Arun District Council
Arun Civic Centre
Maltravers Road
Littlehampton
West Sussex BN17 5LF
Planning & Building Control General Enquiries
Tel: (01903) 737756 Fax: (01903) 730442
Dx: 57406 Littlehampton
Minicom: 01903 732765
e-mail: planning@arun.gov.uk
website: www.arun.gov.uk/planning

Application No: Y/127/21/RES
Site Address: Land at Bilsham Road Yapton
Description of works: Approval of reserved matters (appearance, landscaping, layout and scale) following the grant of Y/91/17/OUT for 250 No dwellings with associated parking, road/footway/cycleway provision, open space, landscaping, surface water attenuation & ancillary works (resubmission following Y/152/20/RES). this site is not CIL Liable as in Yapton Strategic Site.

OWPC41195

YPC have fully considered this revised application and would conditionally support it subject to the following amendments being made:

PROJECT:	Bilsham Road Development LLP	Land at Bilsham Road, Yapton
SCALE:	1:100 (A1 ORIGINAL)	DRAWING: Apartment Blocks C, D, E, F 1BF - Elevations - Drove
DRAWN: RDB	19284	P216
DATE: July 2021		—

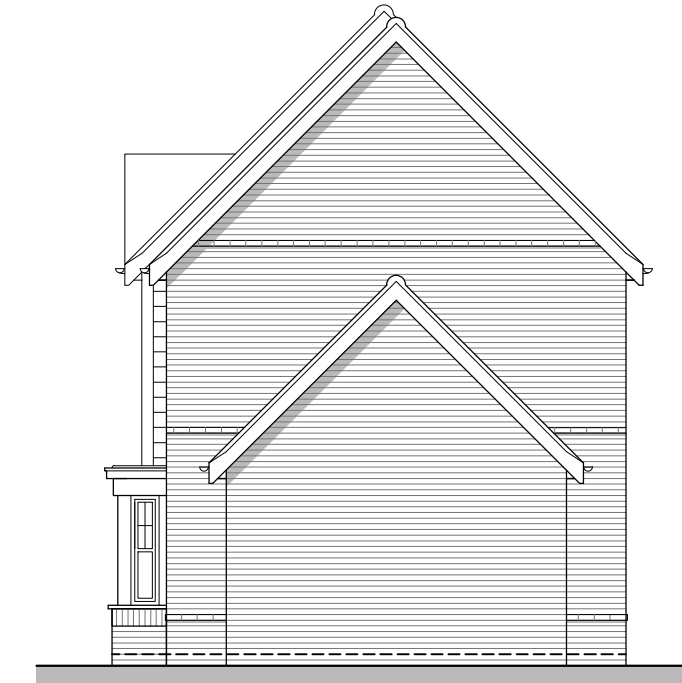
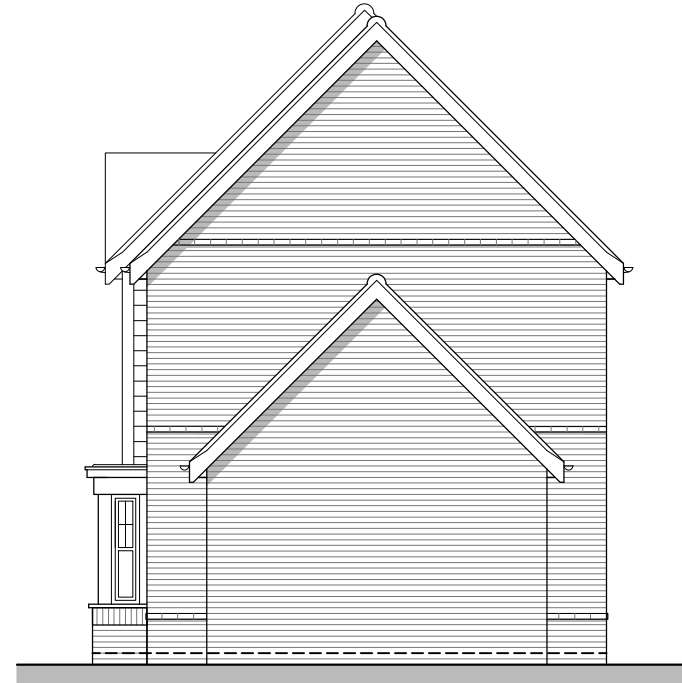
YPC on all larger housing schemes have encouraged developers to ensure that all main access roads frontages are varied in landscaping and use of materials for housing as well as buildings' positioning fronting the roads. YPC require that the building line fronting the spine road is varied to reflect the historic elements of Yapton and to provide variety and a rural aesthetic opposed to the current urban feel. The current design fails to achieve this. YPC would ask that the spine road frontage reflects variety in its building line through positioning of buildings.

drawing title
Open Space Provision

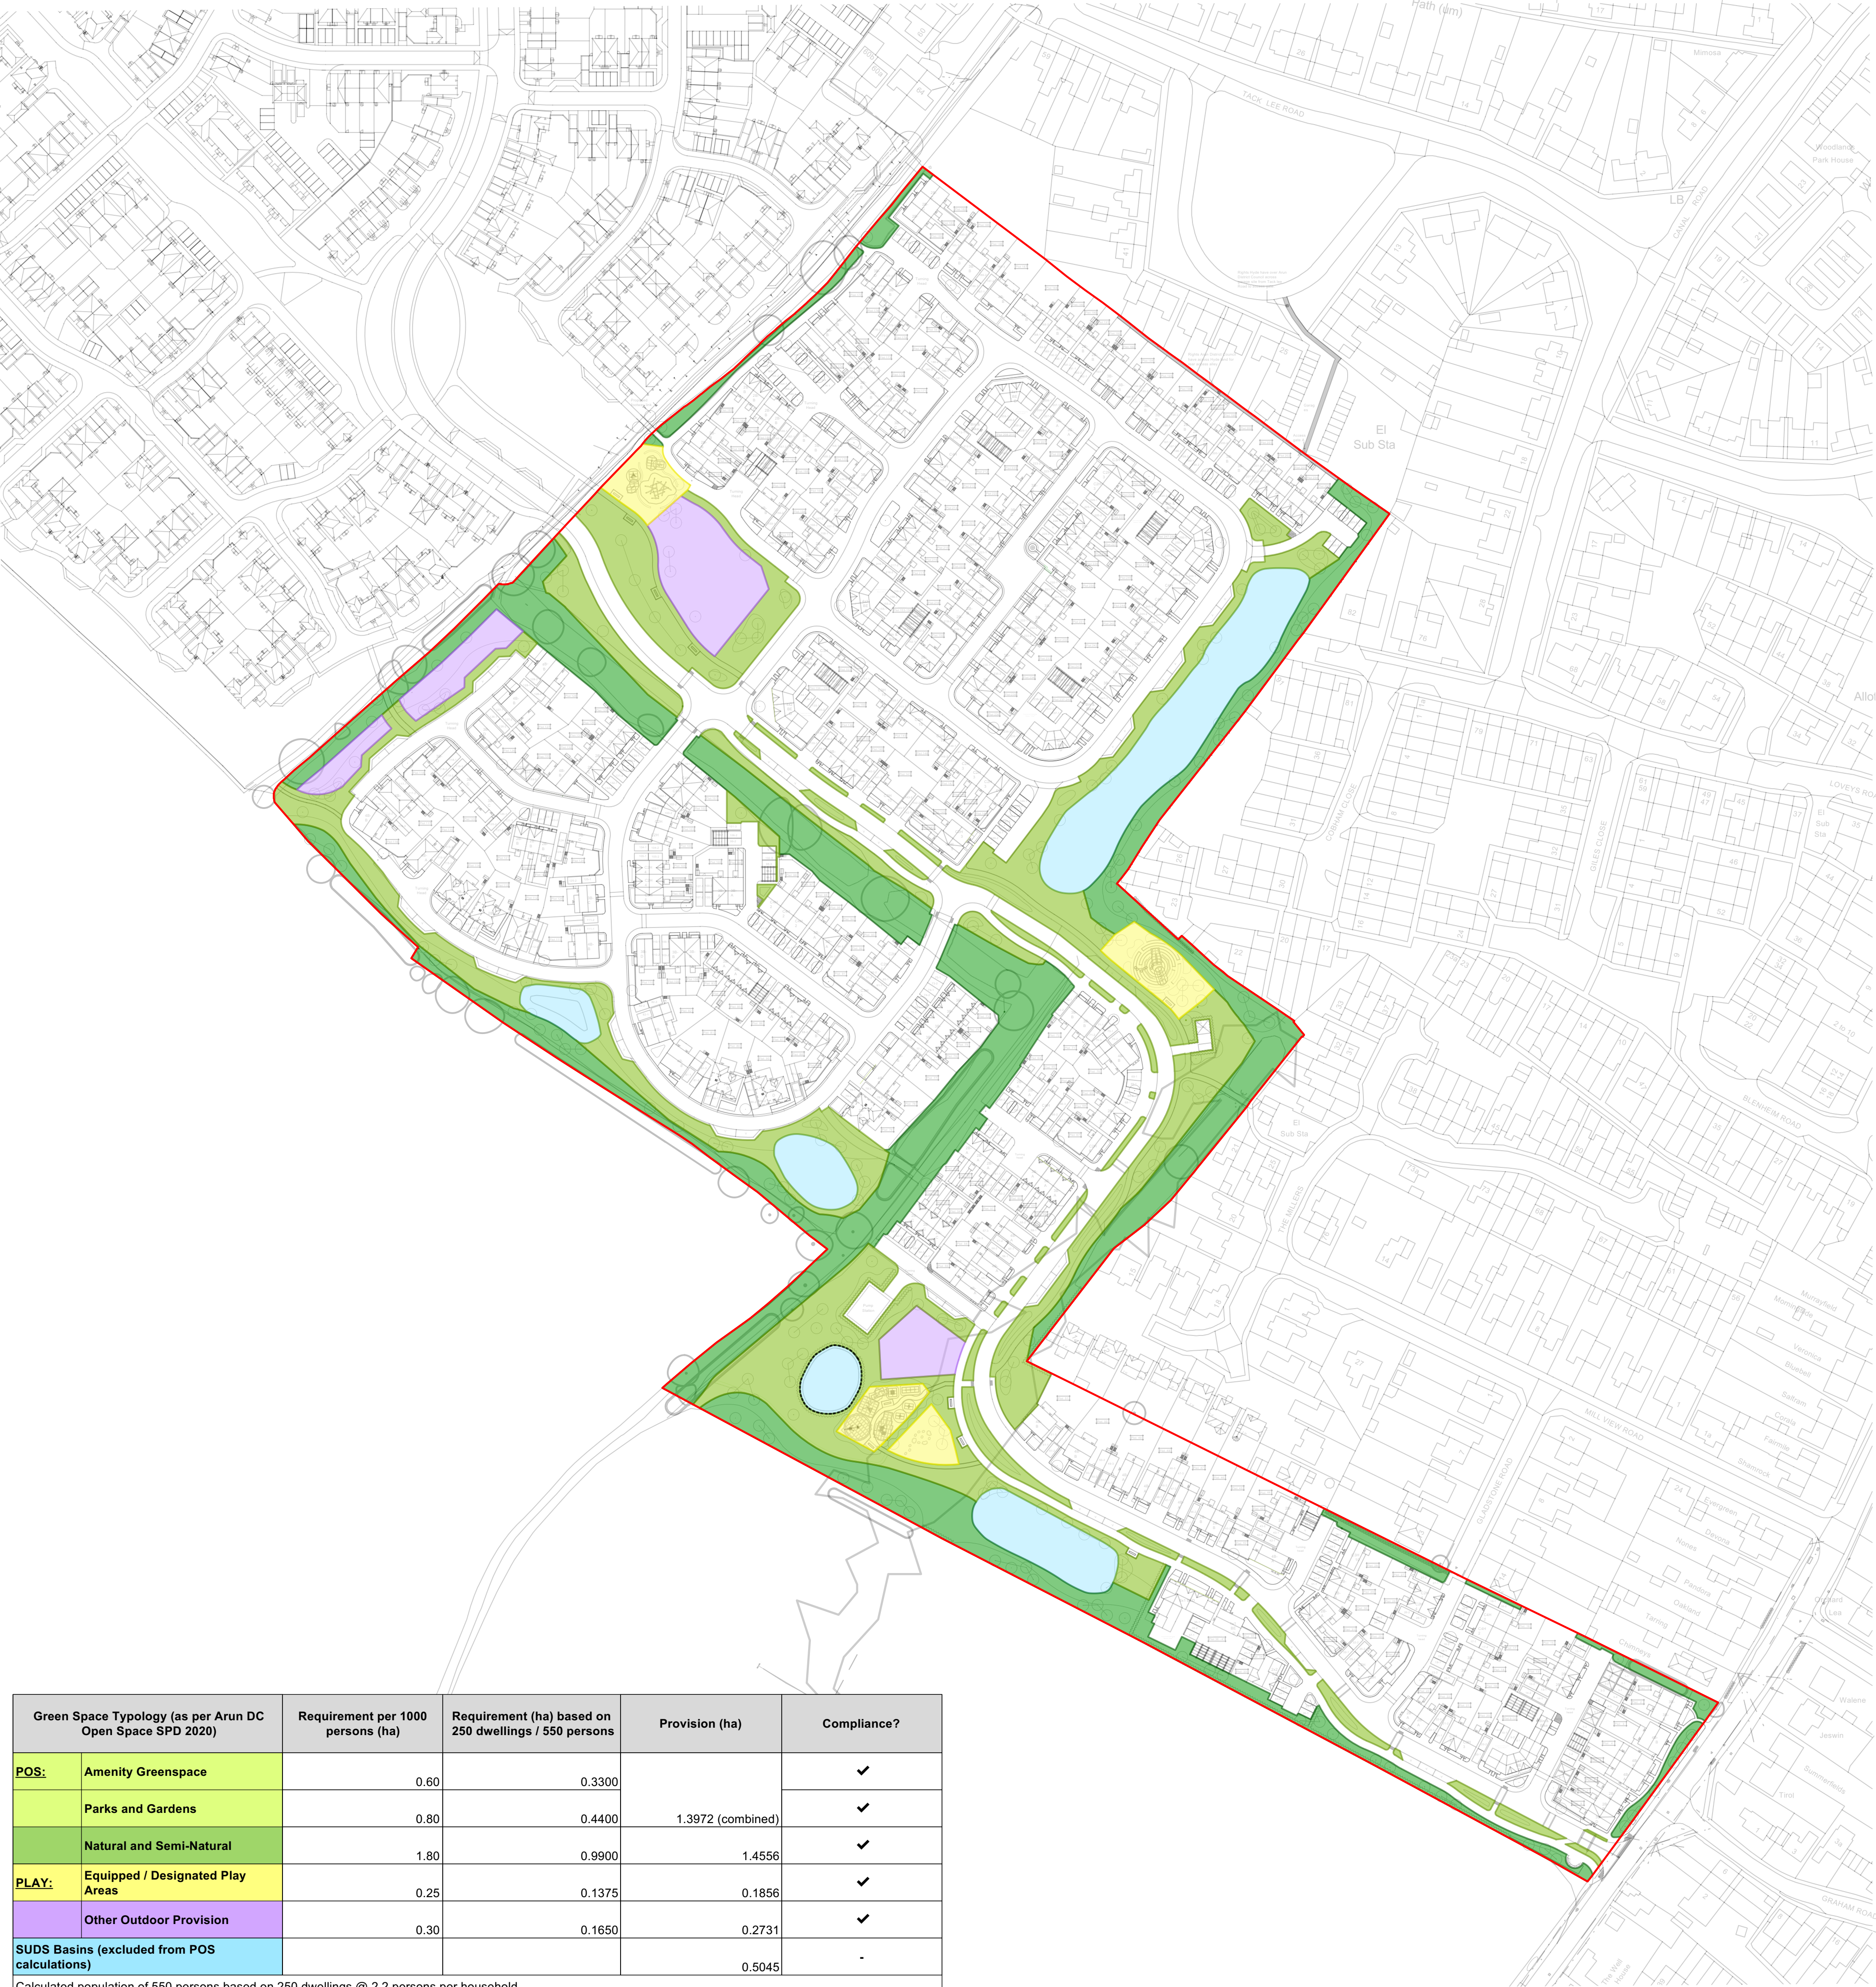
YPC note that the LEAP nearest Drove Lane is still located close to a water collection pool. YPC ask that this be relocated away from the collection pool and nearer the existing nursery facility for both safety reasons as well as a being more accessible to the nursery.
